BOTLEY WEST SOLAR FARM
OXFORDSHIRE HOST AUTHORITIES
RESPONSES FOR
DEADLINE 7 | MONDAY 10 NOVEMBER 2025

Botley West Solar Farm (EN01014)

RESPONSES FOR DEADLINE 7

Photovoltaic Development Partners GmbH
Kurfürstendamm 52
10707 Berlin, Germany

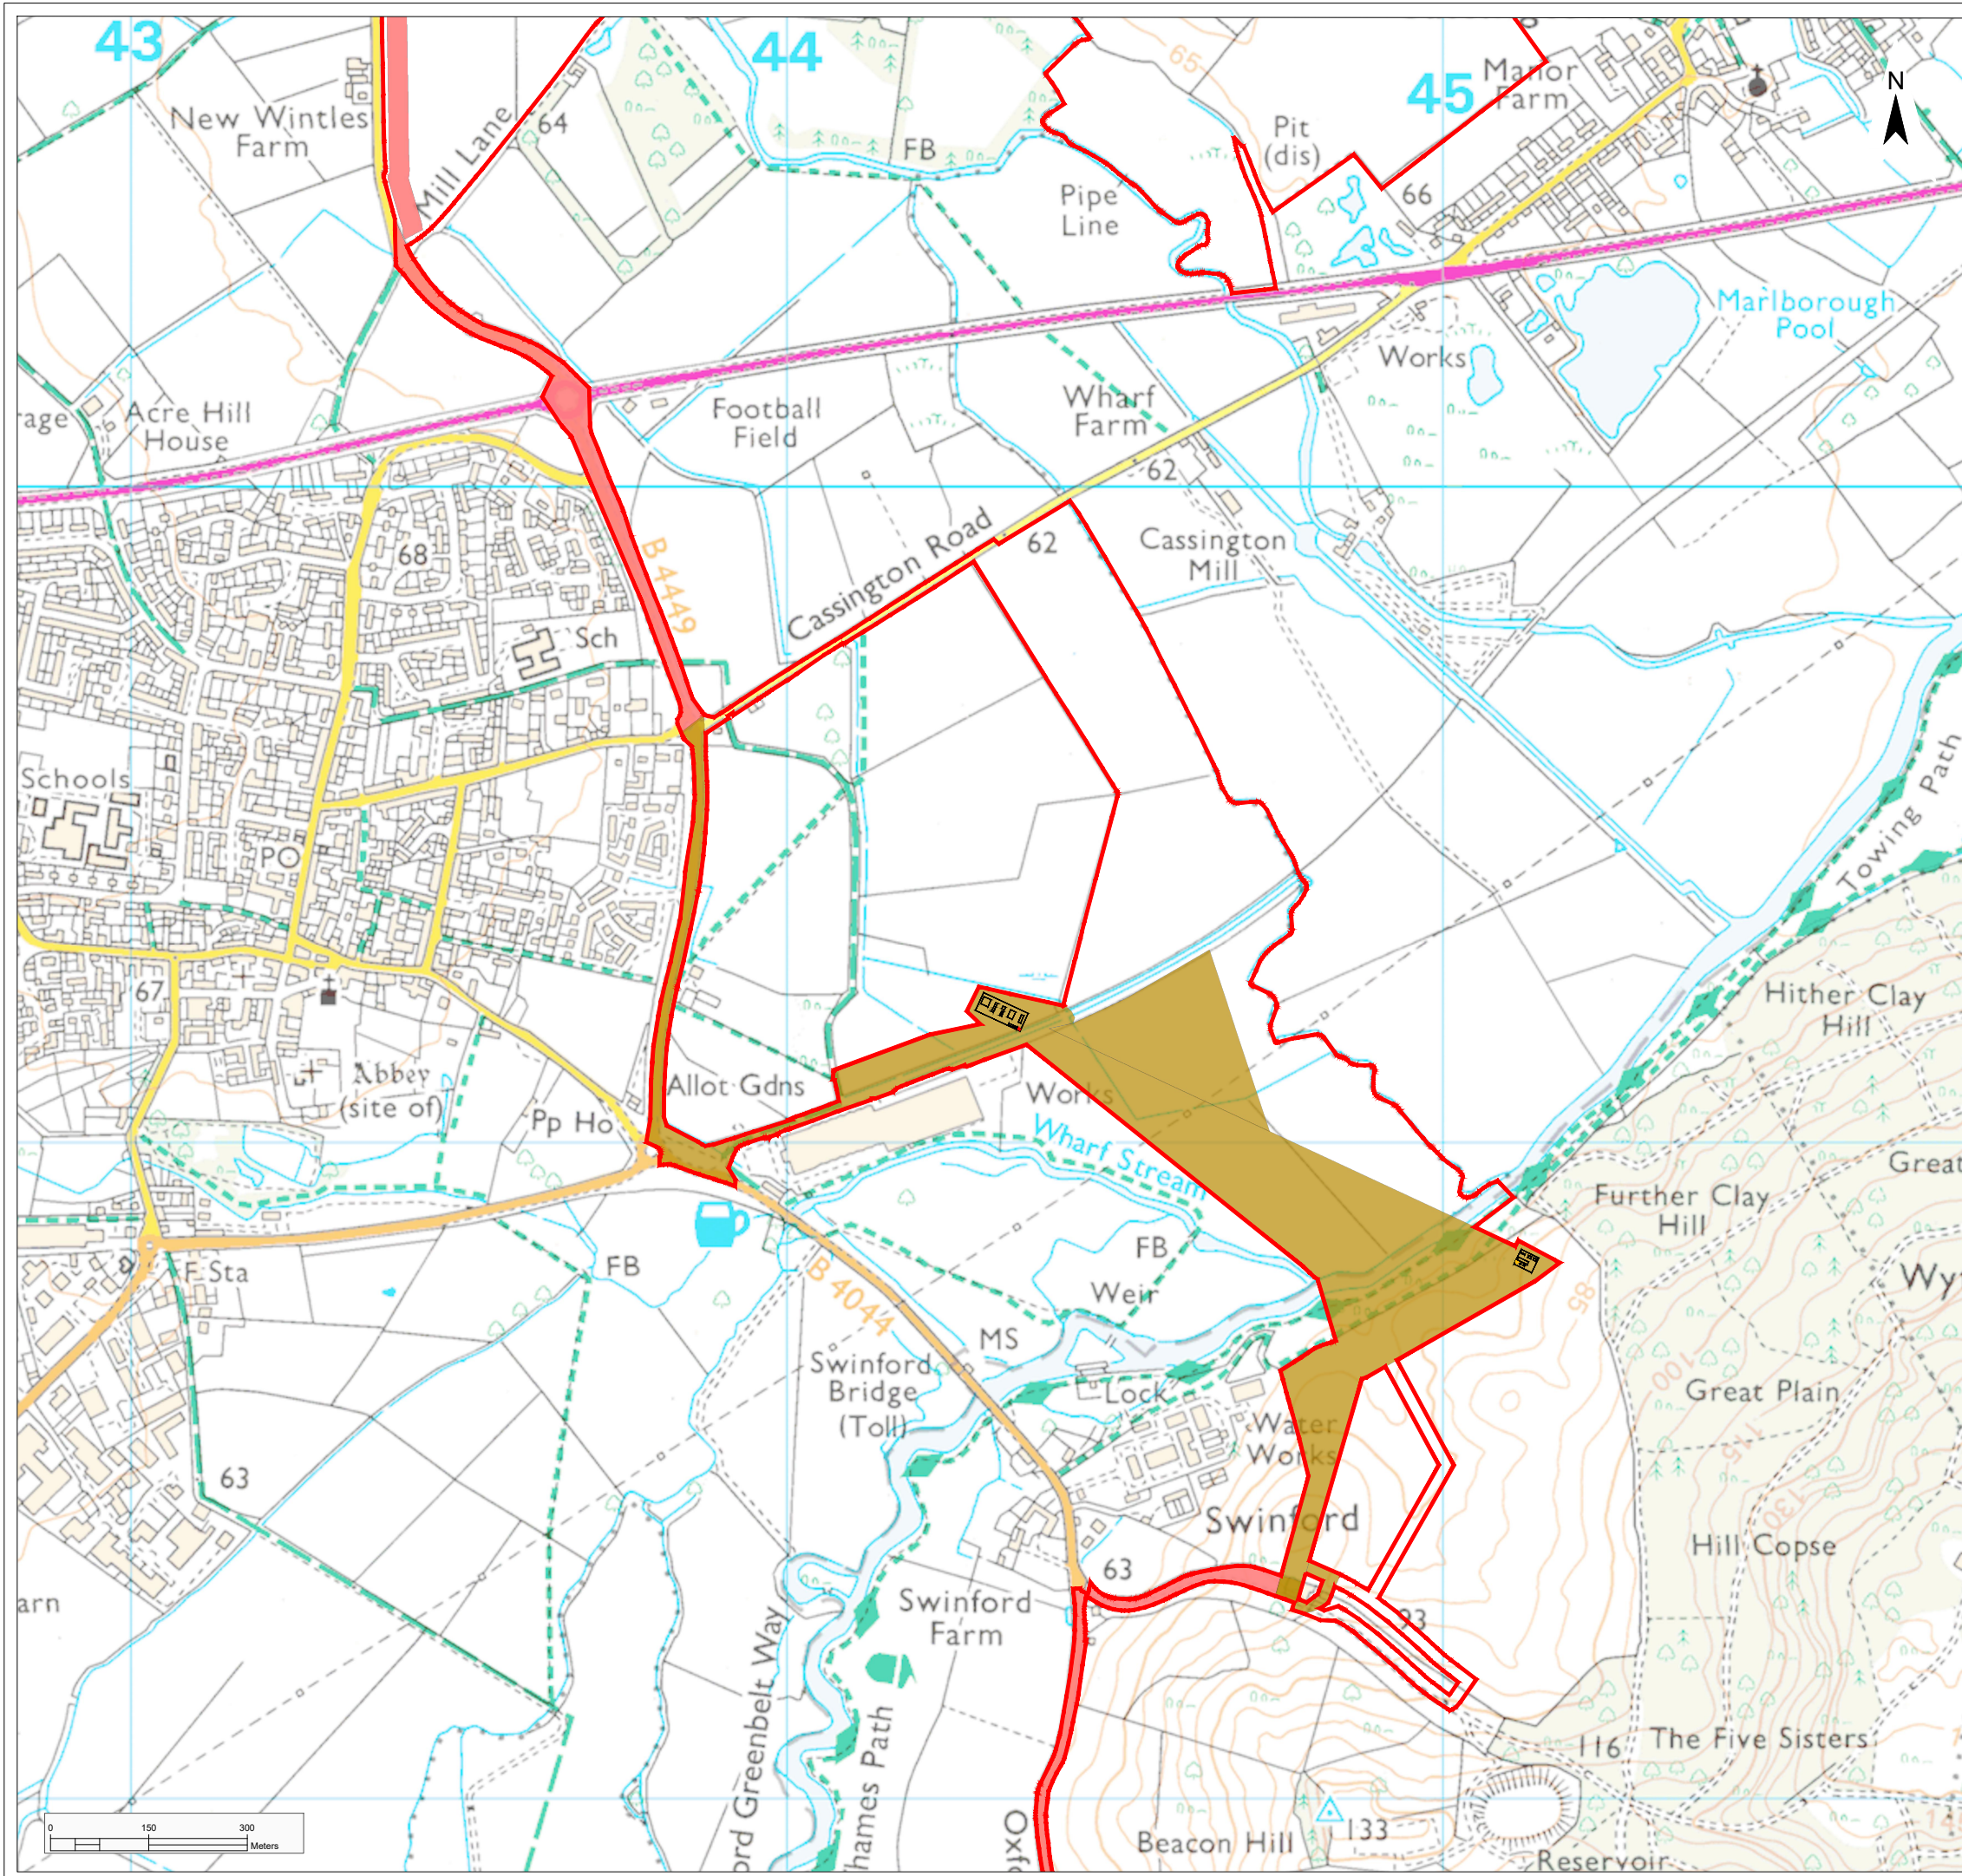
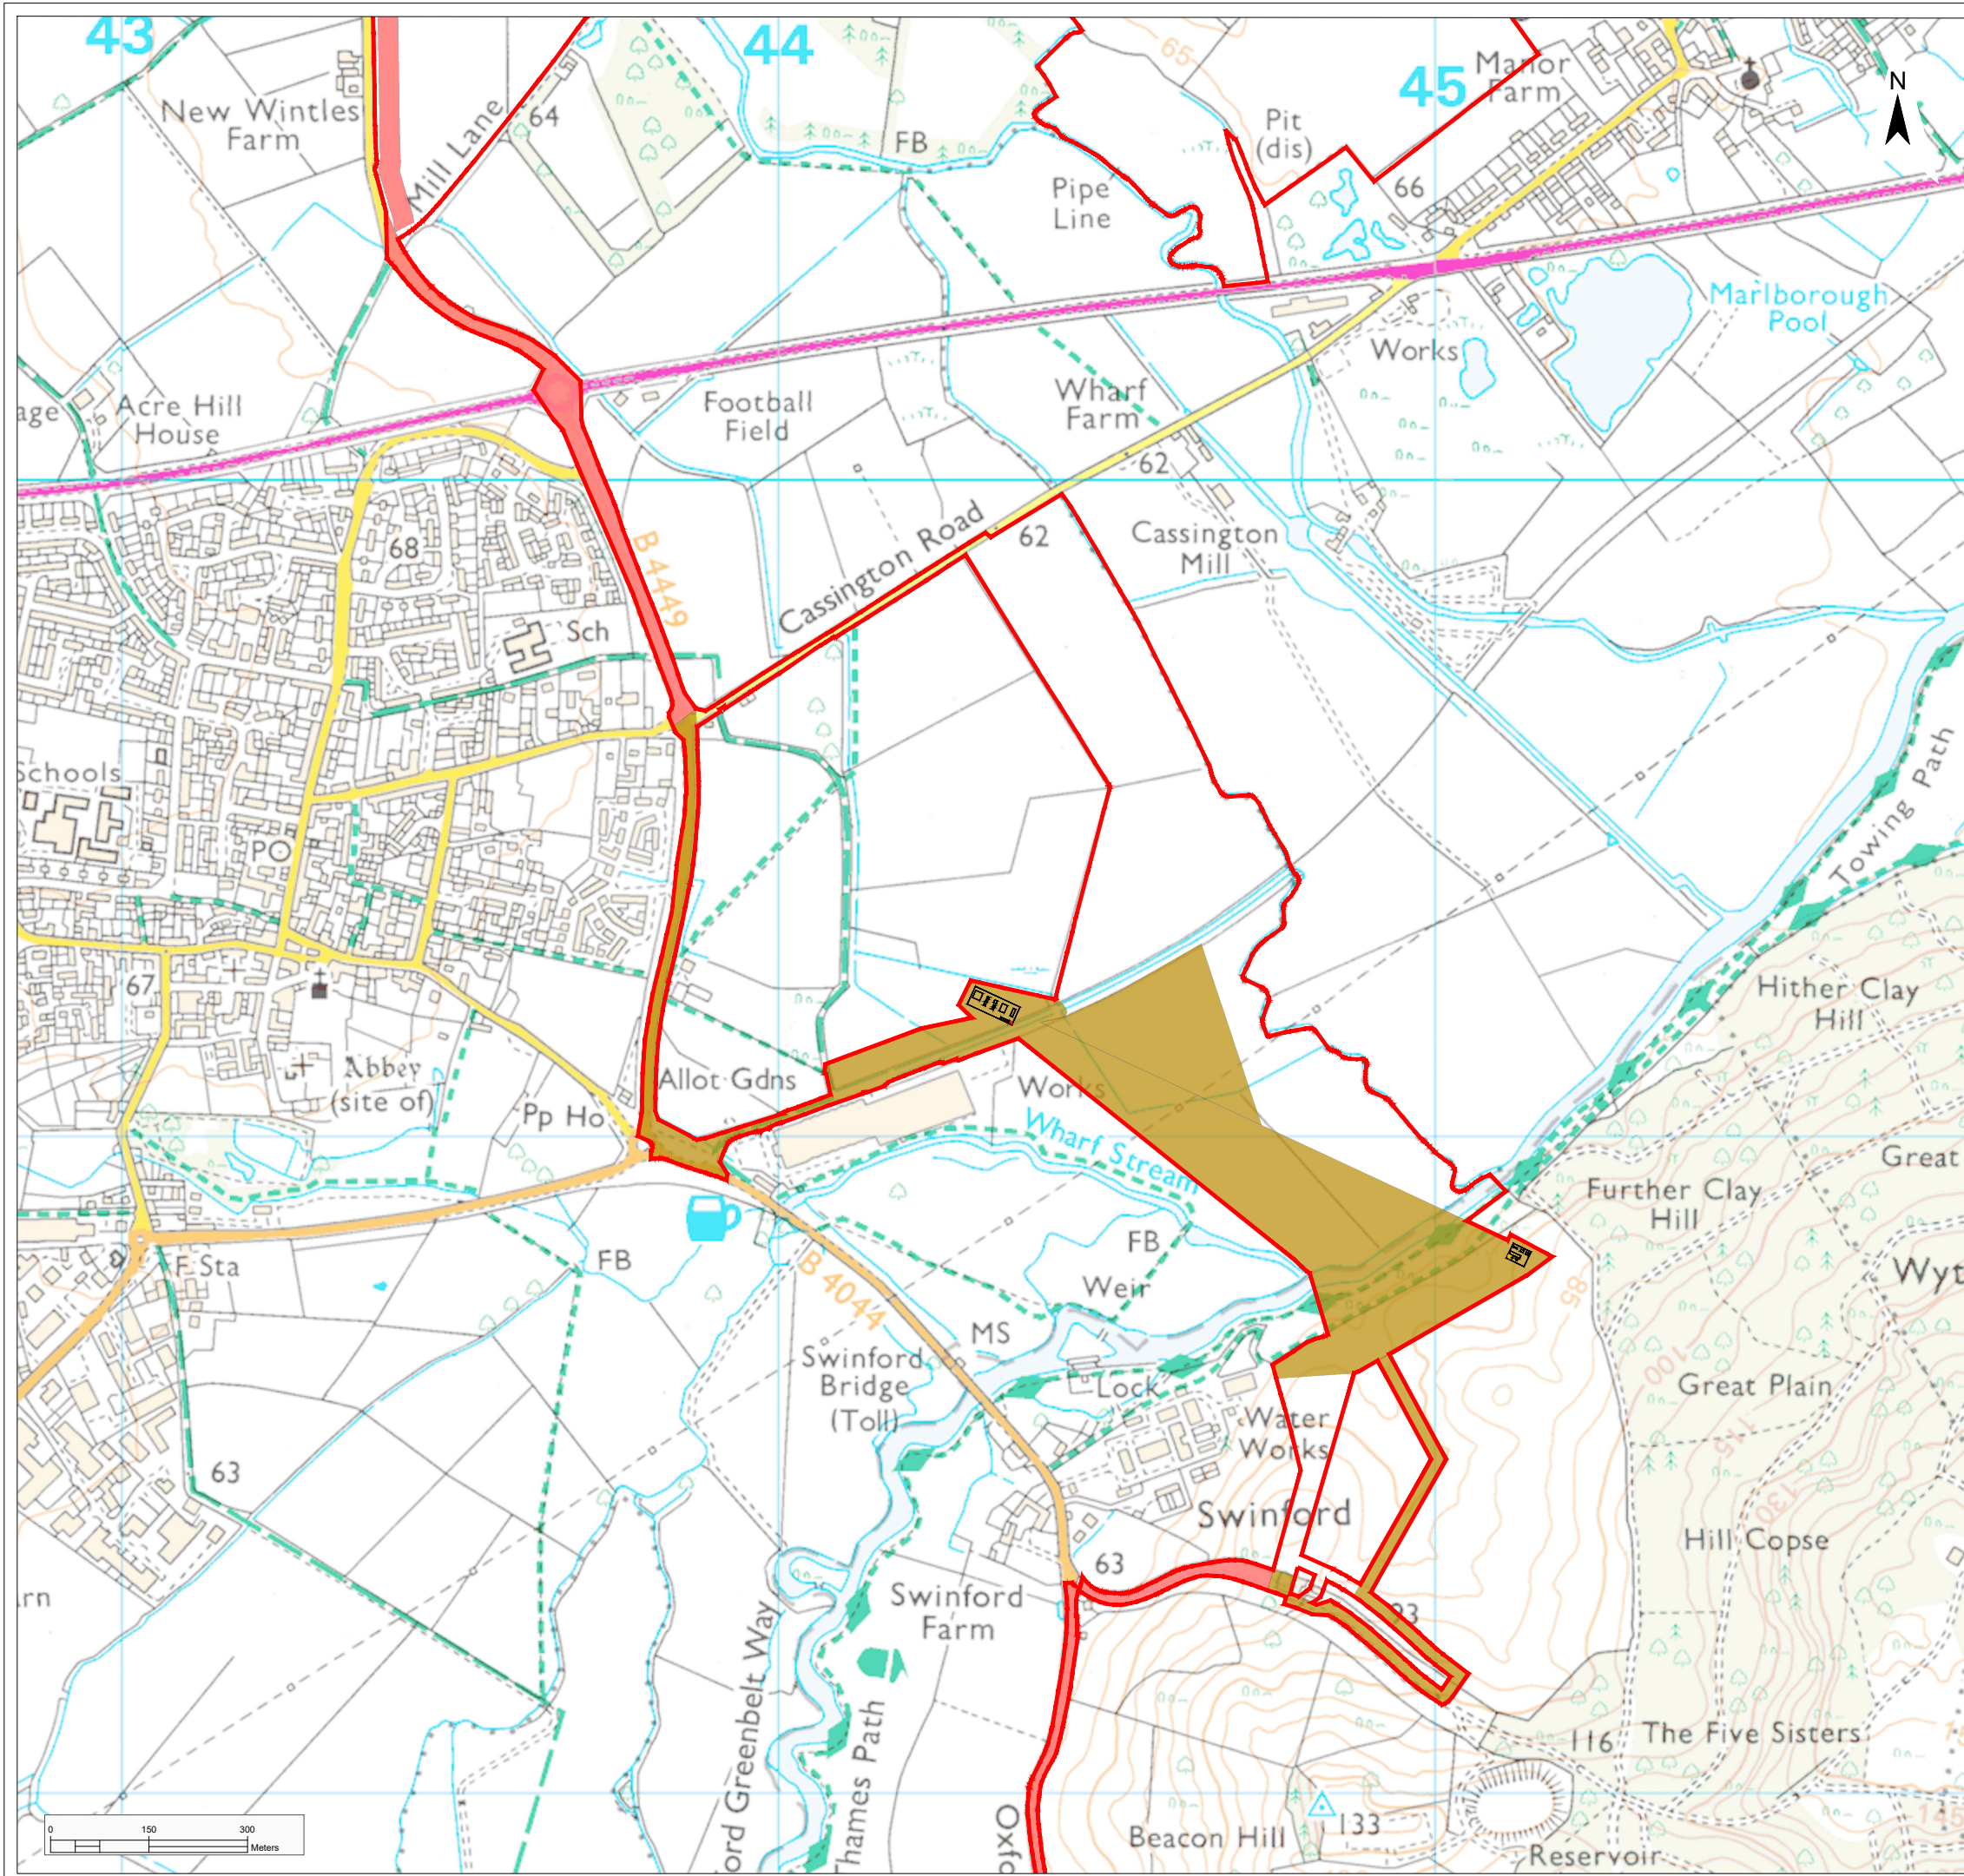
The panels within Field 2.20 have been removed for this field on the illustrative masterplan. If this field is to be part of the scheme however then a buffer area will need to be added to protect the features identified within the NE corner of this field as identified from the evaluation and geophysical survey.
